Re: Letter of Concern 3 regarding Kittitas County Conditional Use Application CU-23-00001

QUESTIONS AND CONCERNS REGARDING KITTITAS COUNTY CU-23-00001

Re: Addendum #1 to 3-8-2023 Letter of Concern regarding Conditional Use Application CU-23-00001, [CU-23-00001 - 3 BR Custom Cuts - Comments Matthew Vaughan, Arrienne & Shannon Bright 3-8-23](#)

Re: Letter of Concern regarding Conditional Use Application CU-23-00001

**3BR CUSTOM CUTS  
PROCESSING PLANT**

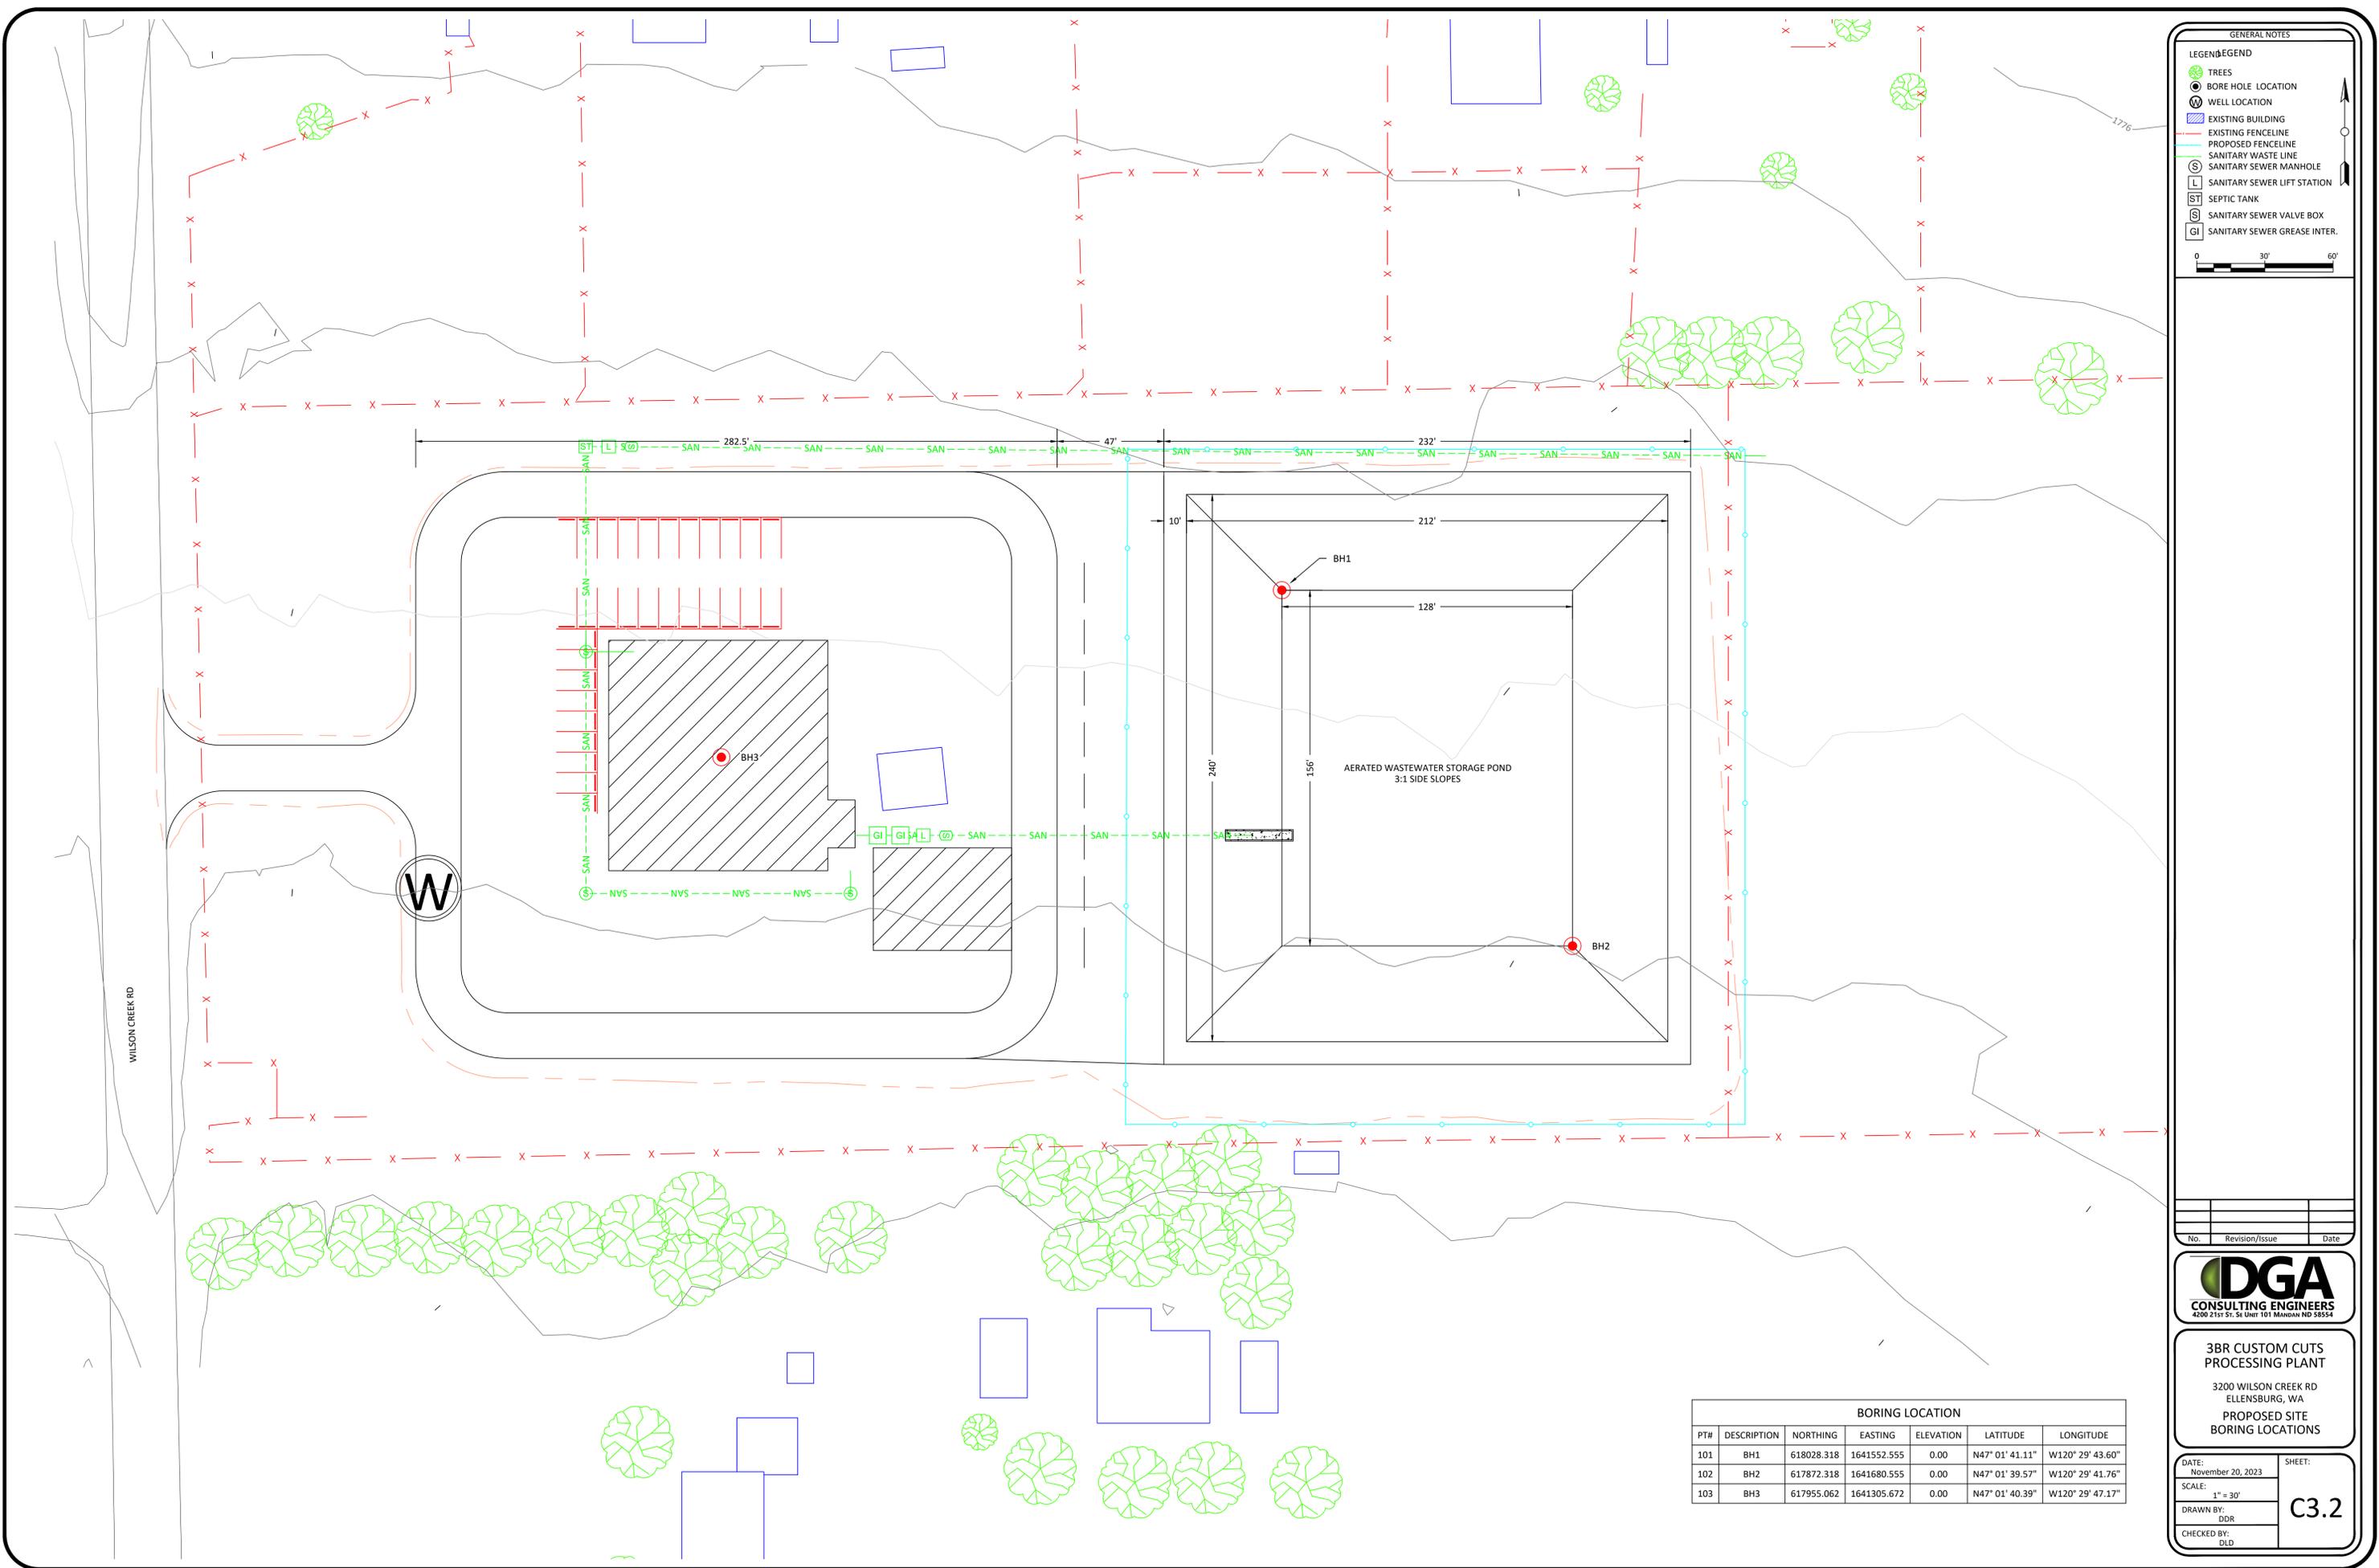
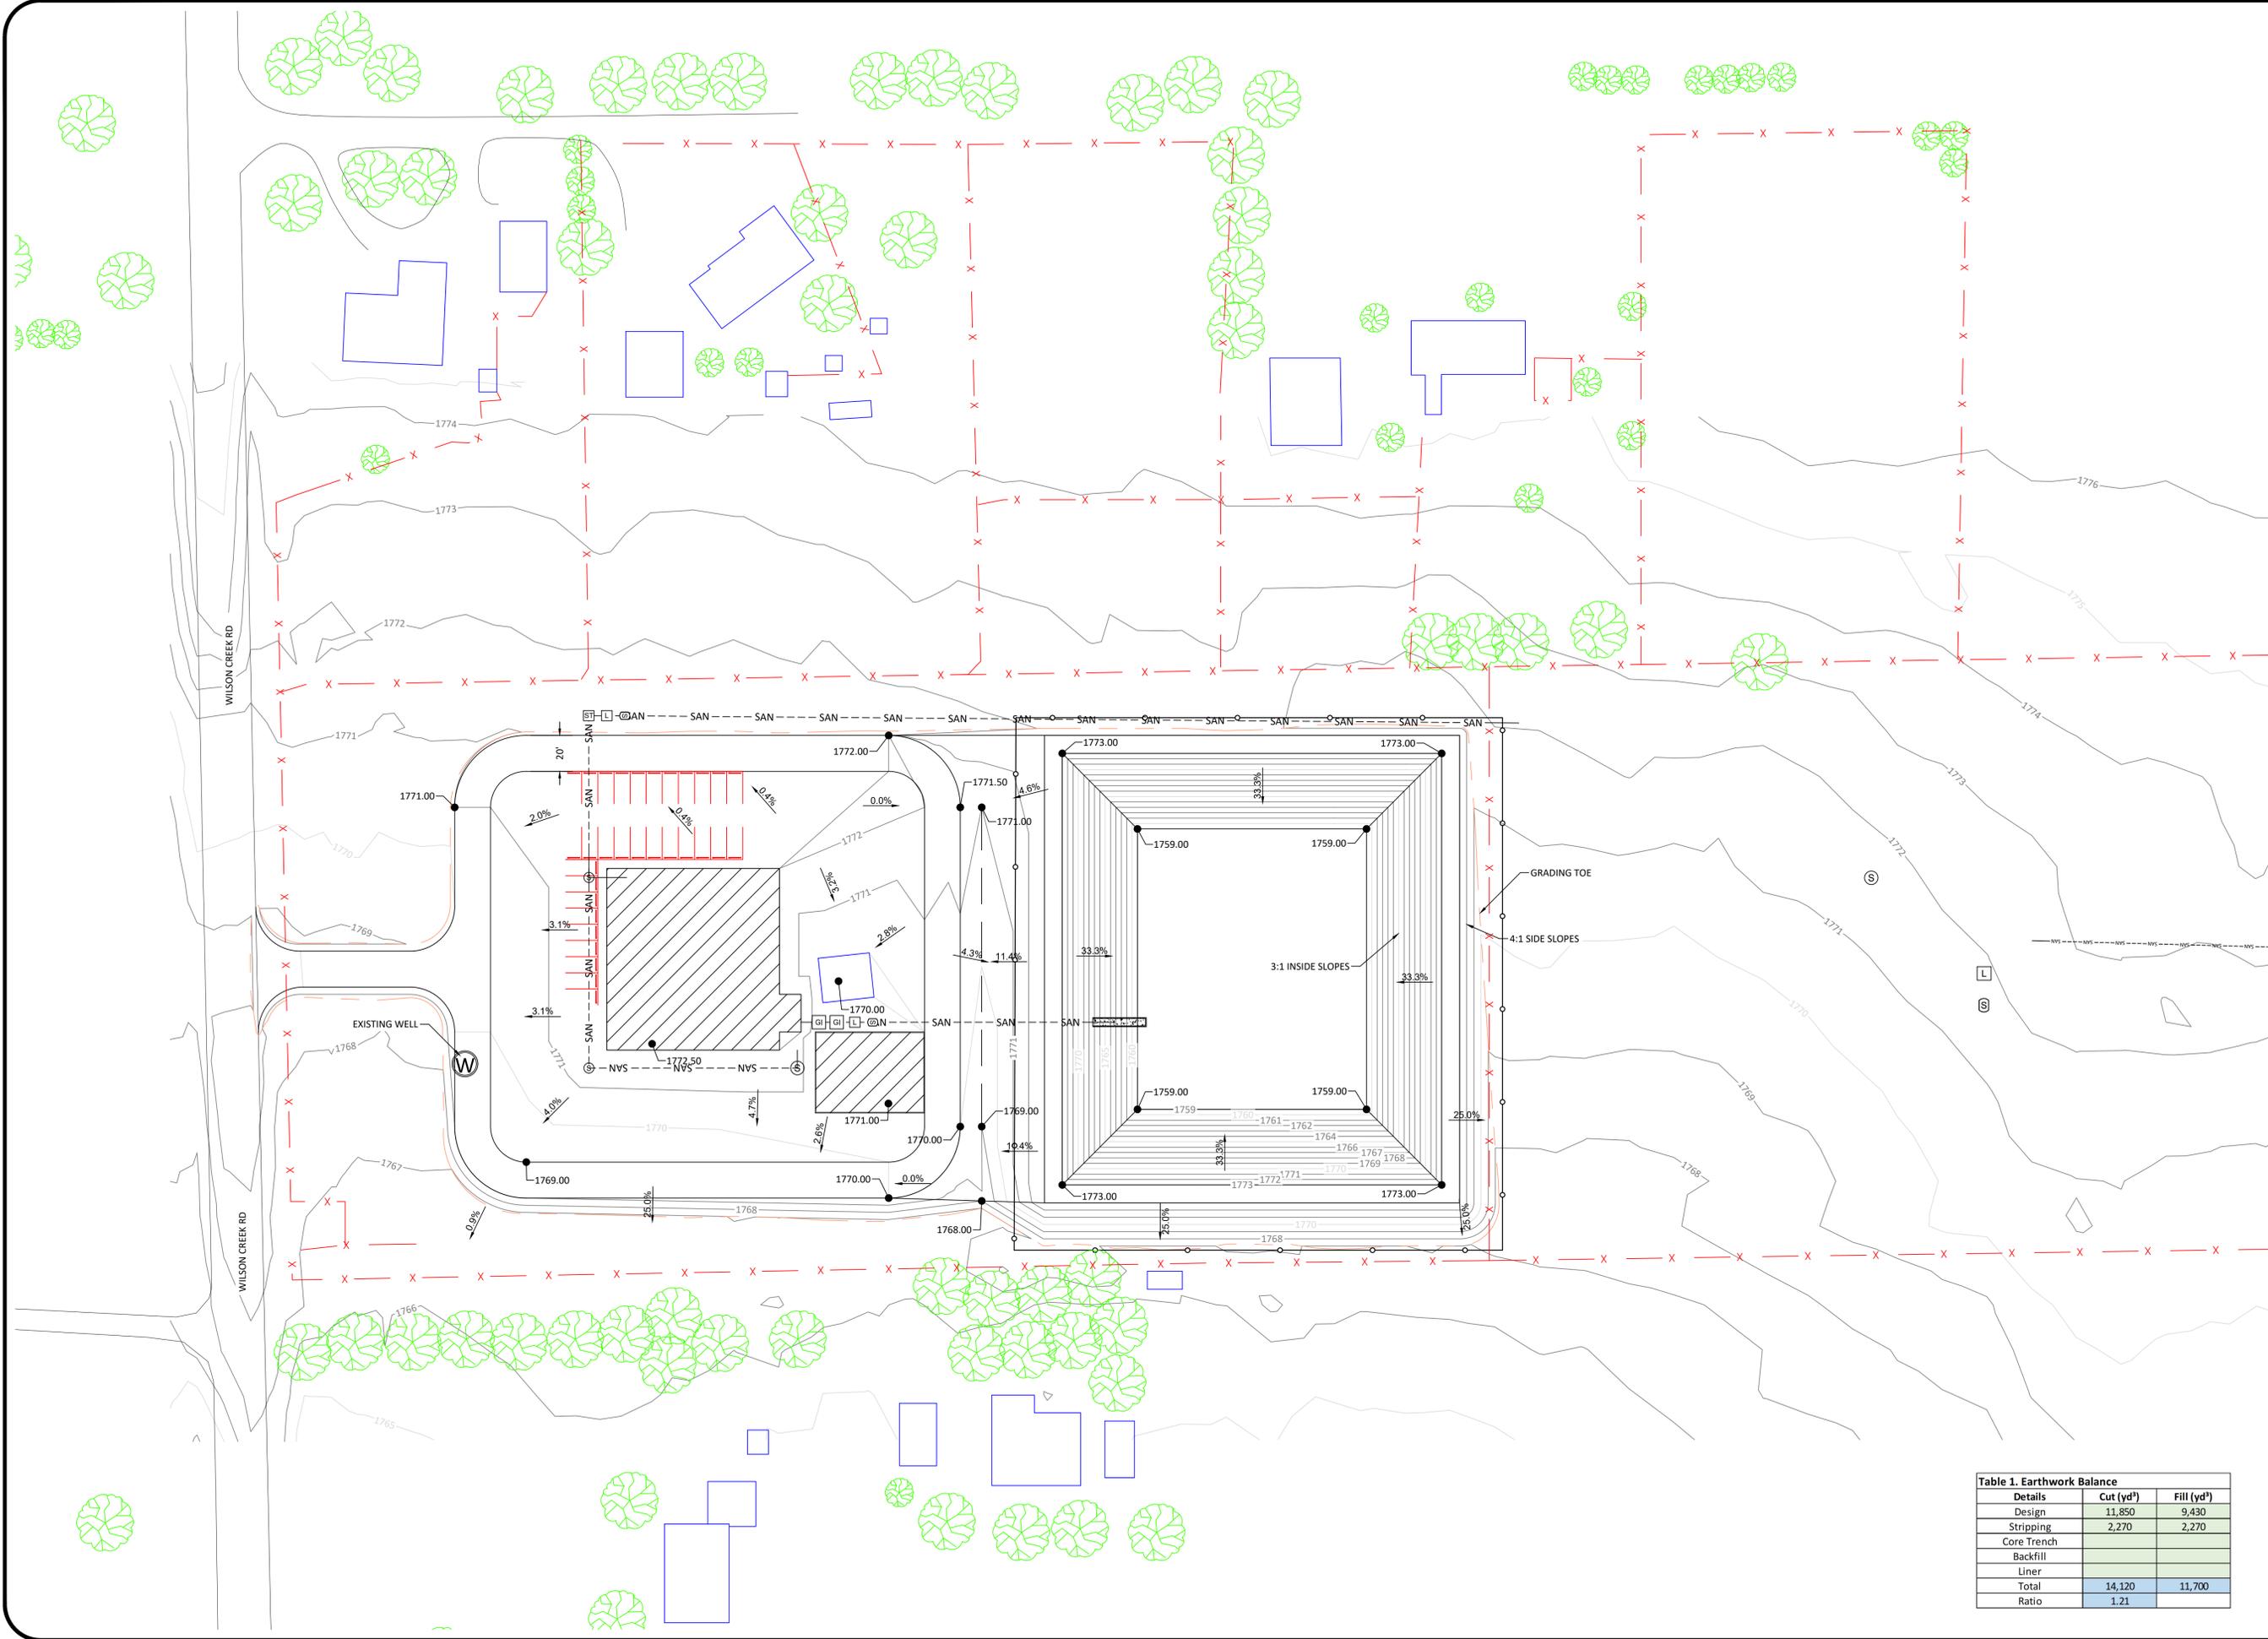
The aerobic pond is a sewage treatment plant for potential contaminants. The plant area, parking lot, holding pens, and aerobic pond are all densely packed at the western portion of the property adjacent to the public road in the manner of industrial property. The aerobic pond/waste treatment pond is of significant dimensions related to the north south boundaries of the property which the Kittitas County Assessor's Property Map depicts as 317' at the west boundary (it is unclear from the diagram provided within the reapplication but the size of the aerobic pond appears to be 240' from north to south allowing for a mere 38.5" to be divided for a scant buffer between the adjacent properties to the north and south of the site (the diagram does not clearly denote the distant from the pond to the property boundaries on the north and south). It appears the aerobic pond is closer to the northern boundary of the property, and it is unclear whether there will be room for trees at the northern side of the aerobic pond. A fence and trees will not cure the blight that this facility would be to the visual and natural

landscape to our neighborhood. Furthermore, trees and their roots could present a risk to the integrity of the pond liner. This configuration seems totally contrary to the "rural character of the neighborhood" and is in no way equivalent to grazing cattle which enhances the rural character—it amounts to a conversion from Ag-5 to Industrial zoning.
